WEST SUSSEX COUNTY COUNCIL CONSULTATION

TO:	Arun District Council FAO: Anita Gardner
FROM:	WSCC - Highways Authority
DATE:	1 April 2020
LOCATION:	White Lodge Hangleton Lane Worthing BN12 6PP
SUBJECT:	A/32/20/PL Erection of 1 No. detached low-profile bungalow with attached garage. This application is a Departure from the Development Plan & may affect a Public Right of Way.
DATE OF SITE VISIT:	n/a
RECOMMENDATION:	Advice
S106 CONTRIBUTION TOTAL:	n/a

SITE PLAN 1:500 @ A4

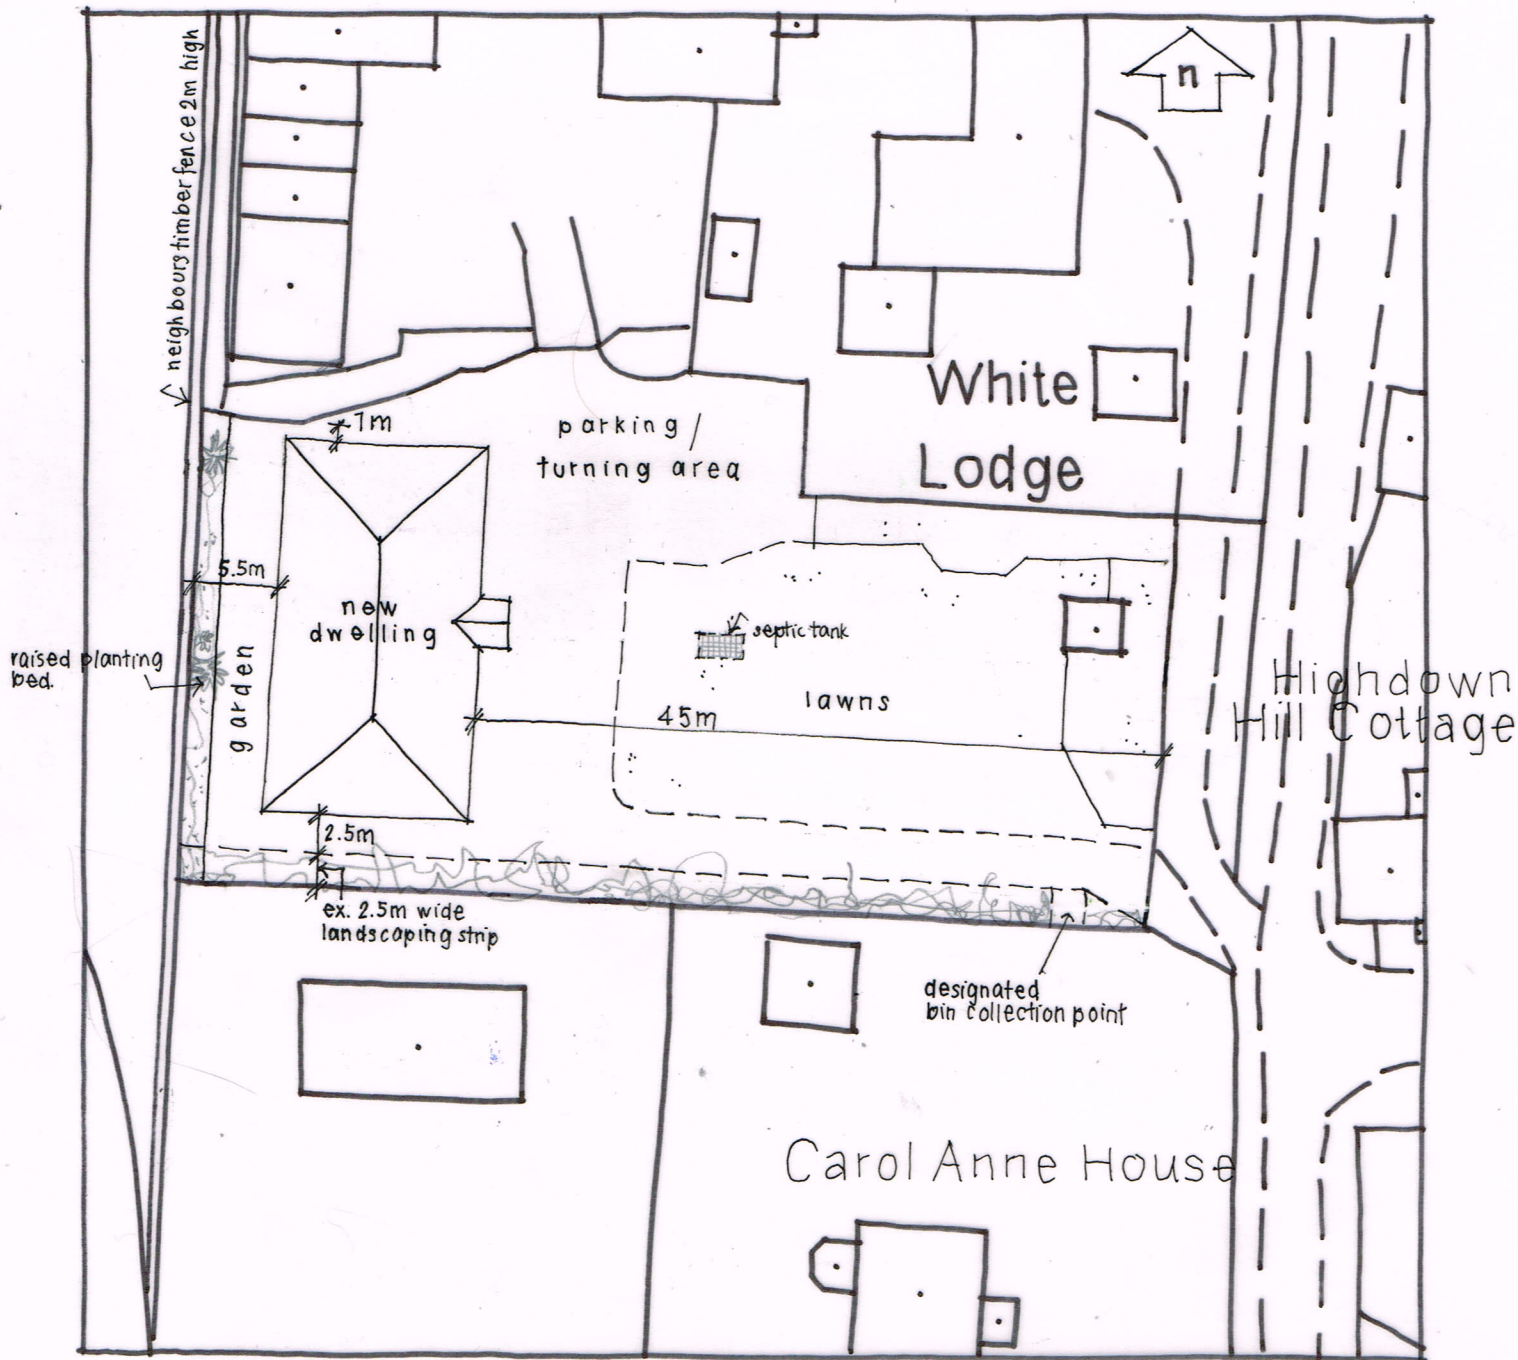
The applicant proposes a 1.5 car parking provision in the garage (5.5 x 7.8 metres - 0.5 spaces) and carport (5.2 x 6.7 metres - one space). The applicant has also provided a Turning and Parking hardstand (20 x 10 metres) to accommodate a turn onsite, visitor parking and any additional parking requirements.

The applicant has not provided cycle parking on their plans. However, given the proposal includes a garage and MfS guidance states that garages are viable spaces to store cycles, the LHA accepts this as covered, lockable storage. If Local Planning Authority (LPA) deem that the applicant should define the location of cycle parking on the plans, then the LHA would advise a suitably worded condition, be attached with plans and details to be provided.

No part of the development shall be first occupied until the car parking has been constructed in accordance with the approved site plan. These spaces shall thereafter be retained at all times for their designated purpose.
